Address: 78 Lingards Road Huddersfield HD7 5HY

Application number: 2025/92156	
What is the application for?:	Erection of 3 apartments (Class C3) with associated amenities (modified proposal
Address of the site or building:	Land at, Lingards Road, Slaithwaite, Huddersfield, HD7 5HY
Postcode:	HD7 5AL

User comments

title:
Proposed Site Plan + Roof Plan

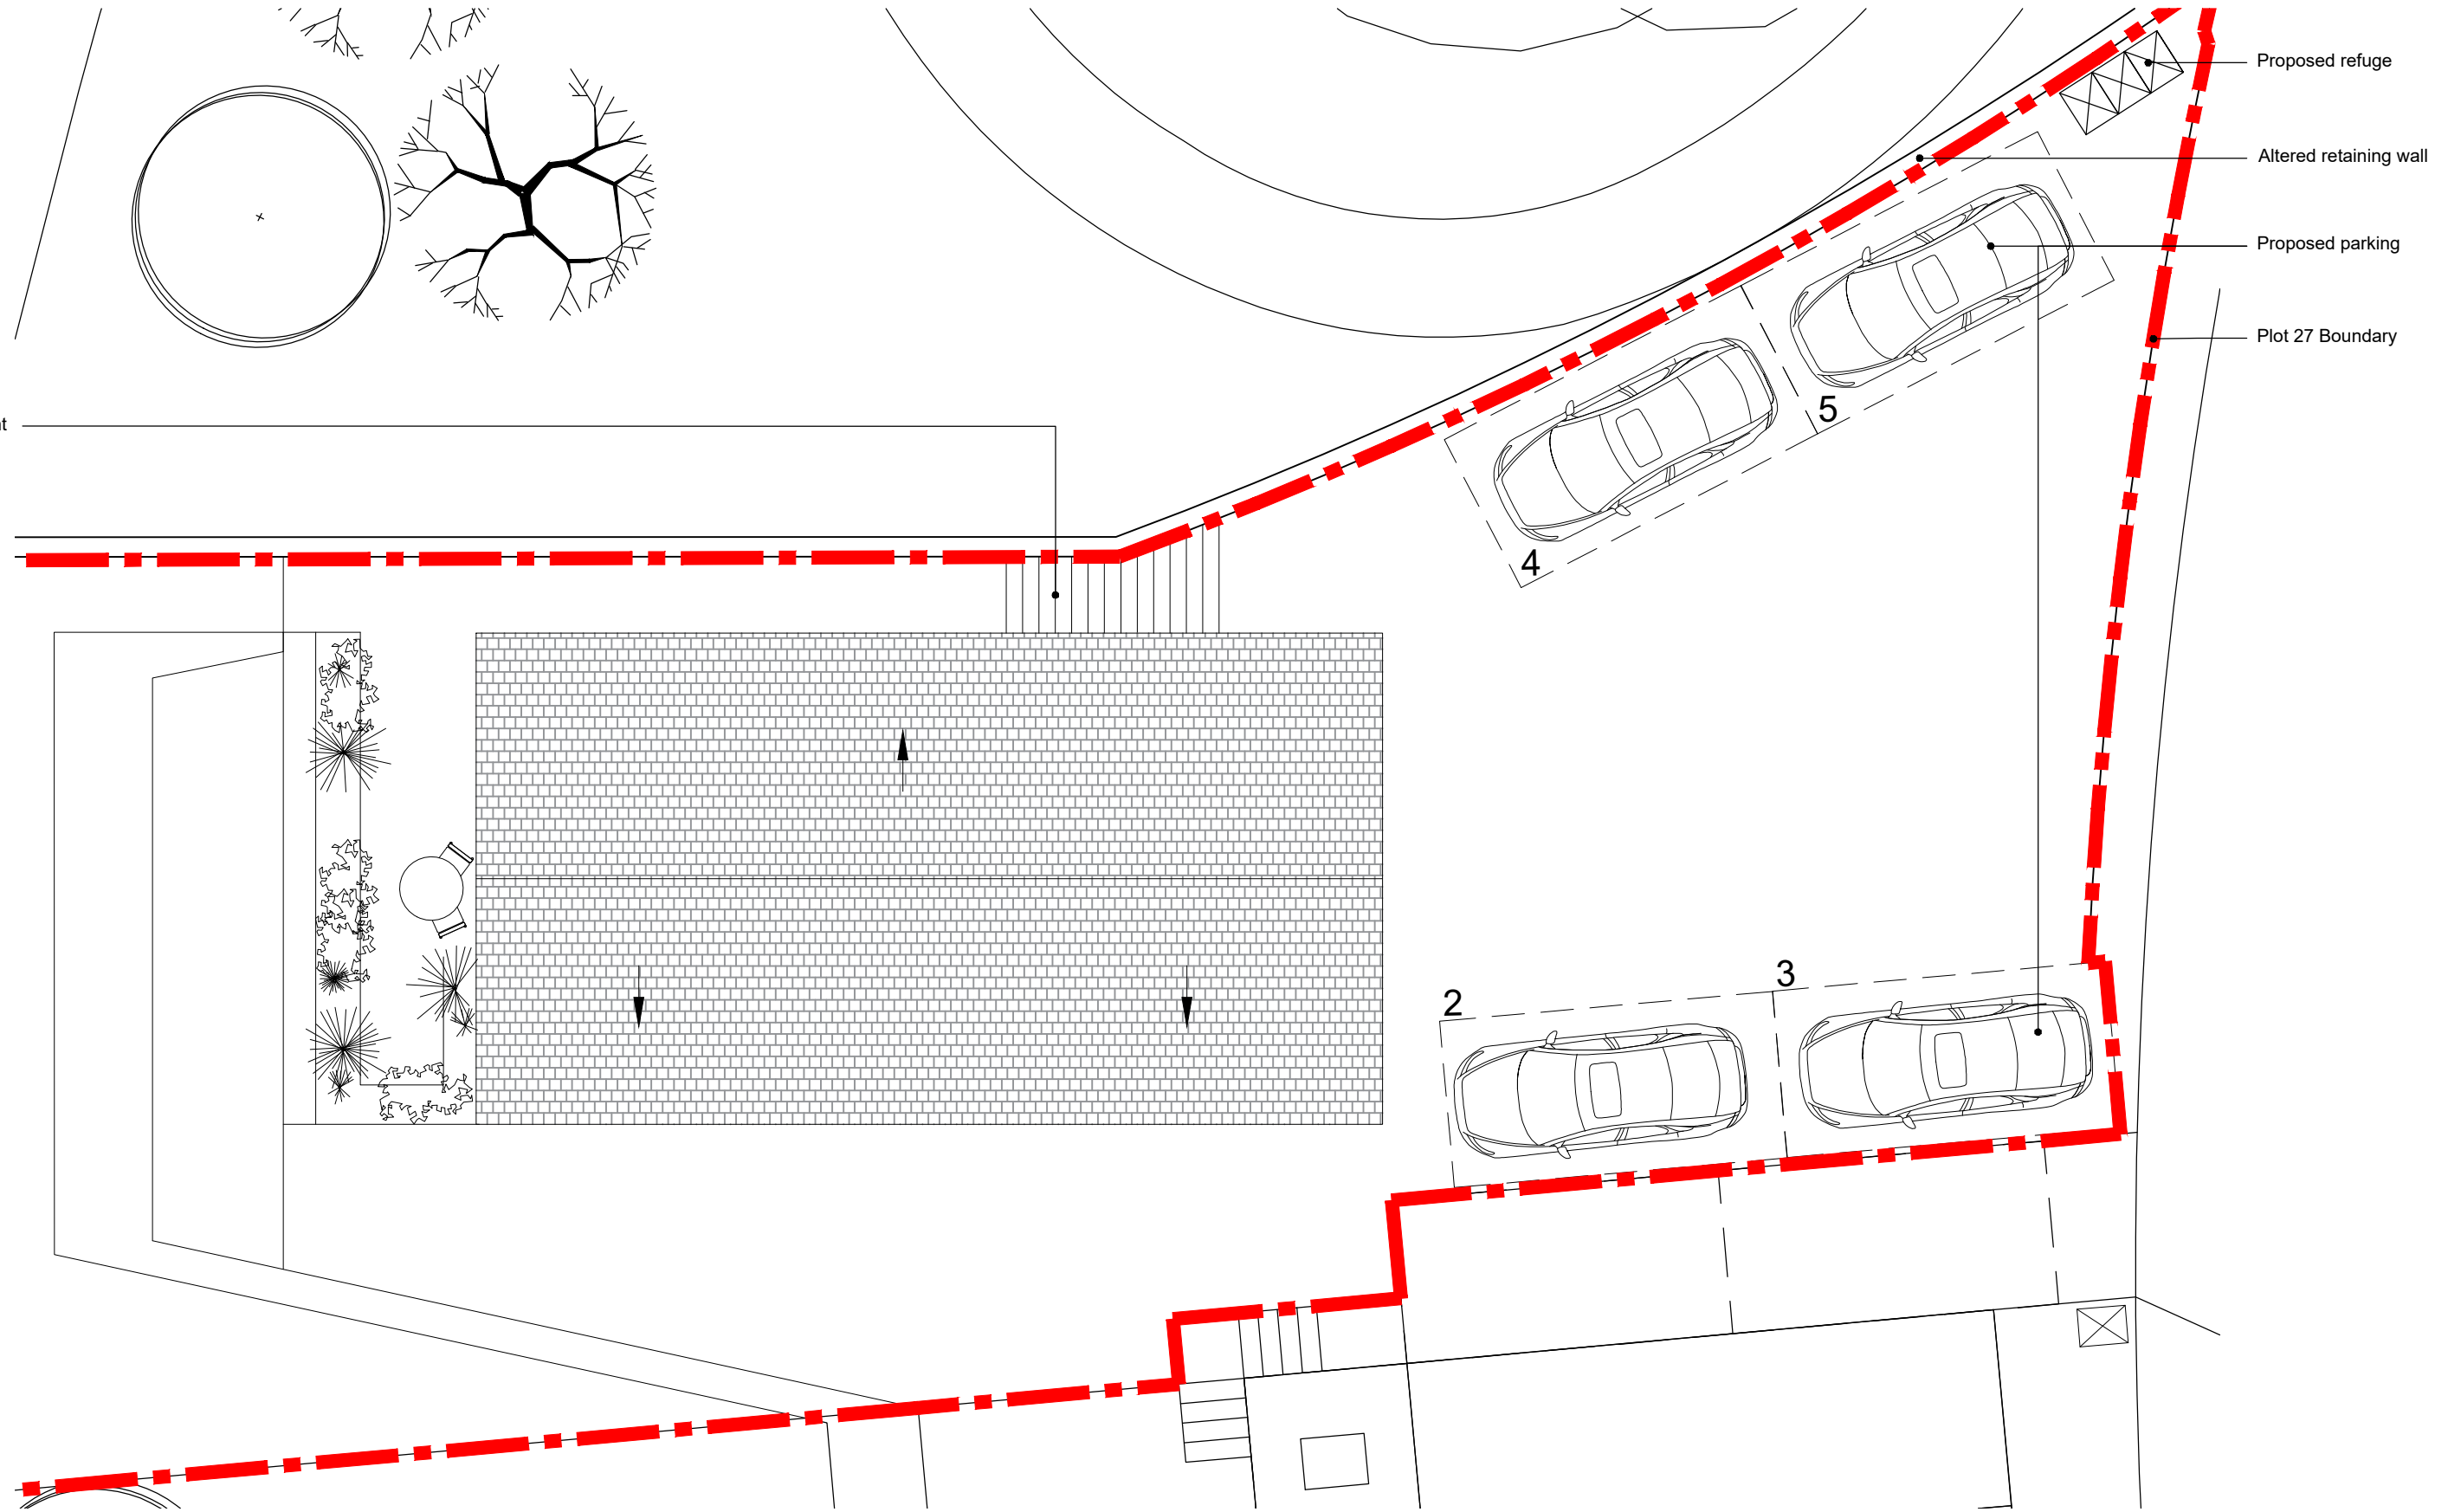
Type of comment: An objection	
Do you wish your comments to be published on the website anonymously?	No
<p>I object to the application as it increases the massing and density of housing, it is a larger and more dominant design than that originally approved. The developer having been given planning permission is now seeking variations and changes on a number of plots on an individual basis that do not comply with the restrictions and conditions imposed by the original decision. The developer is following a policy of building before the variation/change has been considered by the council in the expectation that the works will be allowed to remain as it has been completed.</p>
